Rezoning Transportation Analysis
Petition Number: Insert Zoning Petition #2021-046
General Location Identifier: 08705203

Revision Log:

Date	Description
04-29-2021	First Review (EL&KP)

RZ1.0

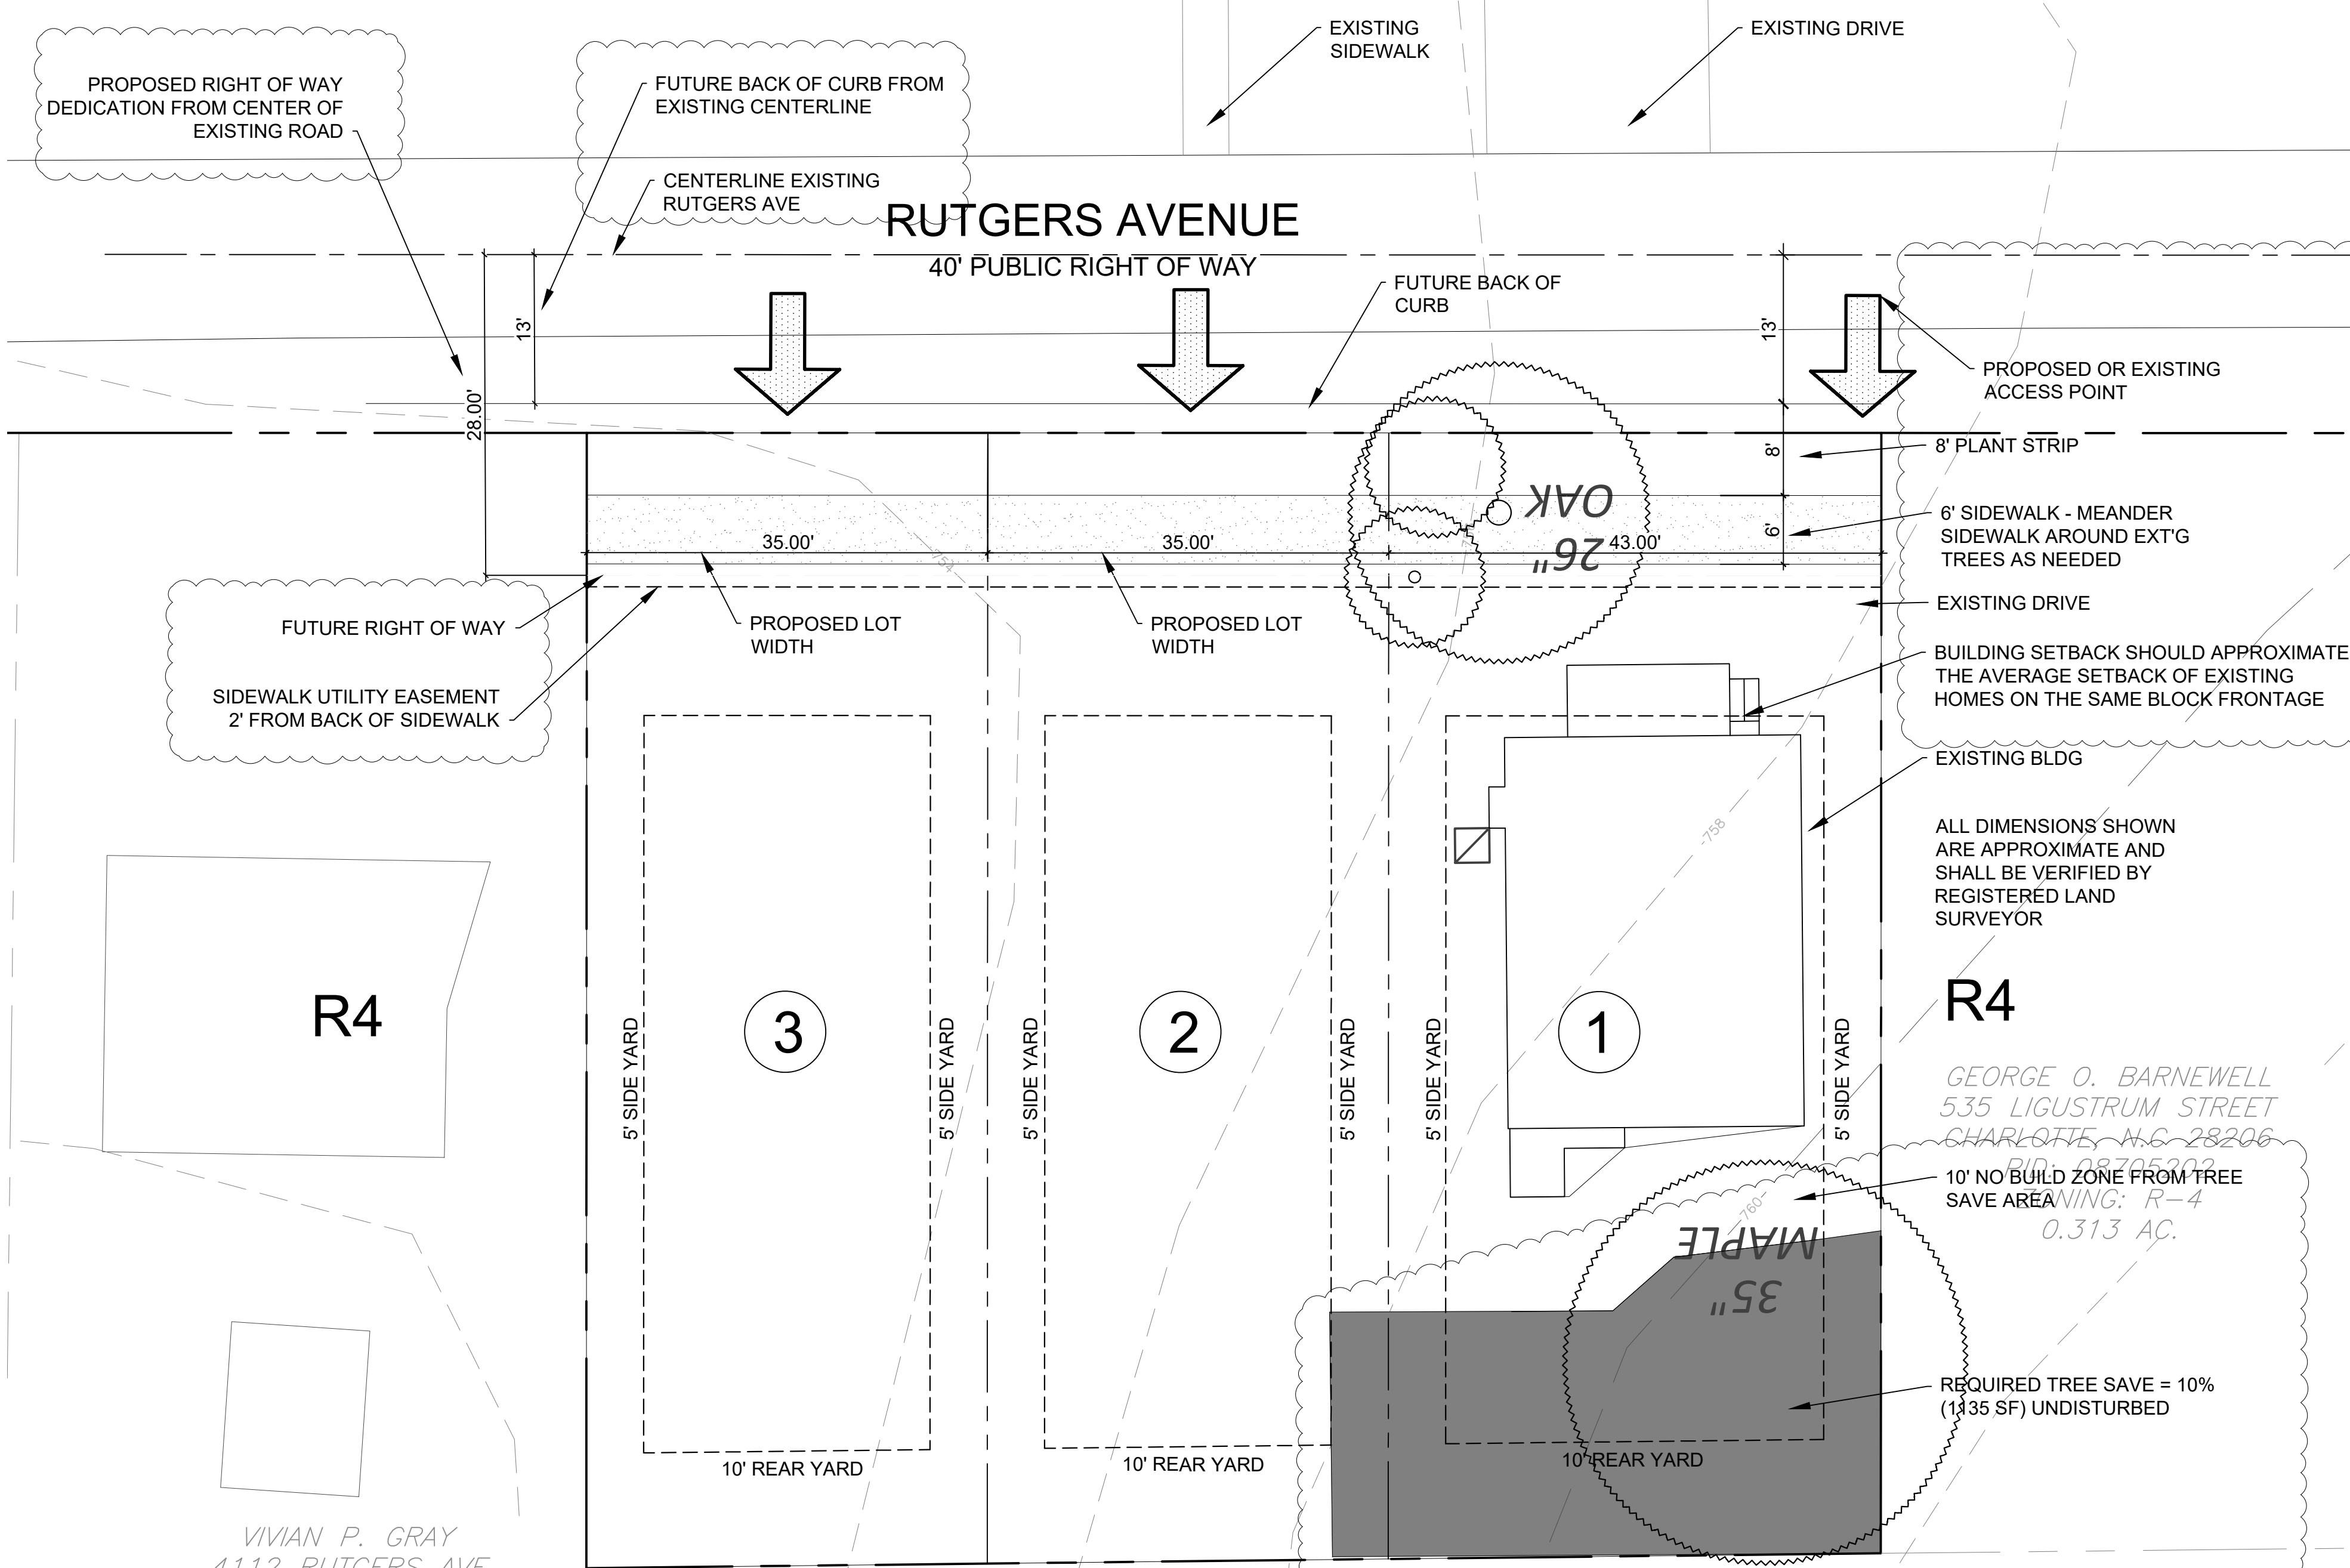
1. **Curb line:** The proposed zoning district has a setback measured from back of the existing or proposed future curb line.
 - a. **Rutgers Avenue:** The future location of curb and gutter will be located 13-feet from the existing centerline to back of curb.

Label and dimension the curb and gutter from the centerline.

3. Revise site plan and conditional notes to commit to dedicate 28-feet of right-of-way from the Rutgers Avenue centerline. The site plan shall label and dimension the right-of-way from the road centerline.

4. Revise site plan and conditional note(s) to commit to construct an 8-foot planting strip, and 6-foot sidewalk along the site's Rutgers Avenue frontage, per Chapter 19. The site plan shall label and dimension both items from the road centerline.

5. Revise conditional note C.2 to "The site will be served by private driveways, as generally depicted on the rezoning plan. Minor adjustments to the driveway locations will be permitted, subject to CDOT approval during the permitting process."

6. Revise site plan by showing the driveway and sidewalk associated with PID 08705403 on the opposing side of Rutgers Avenue.
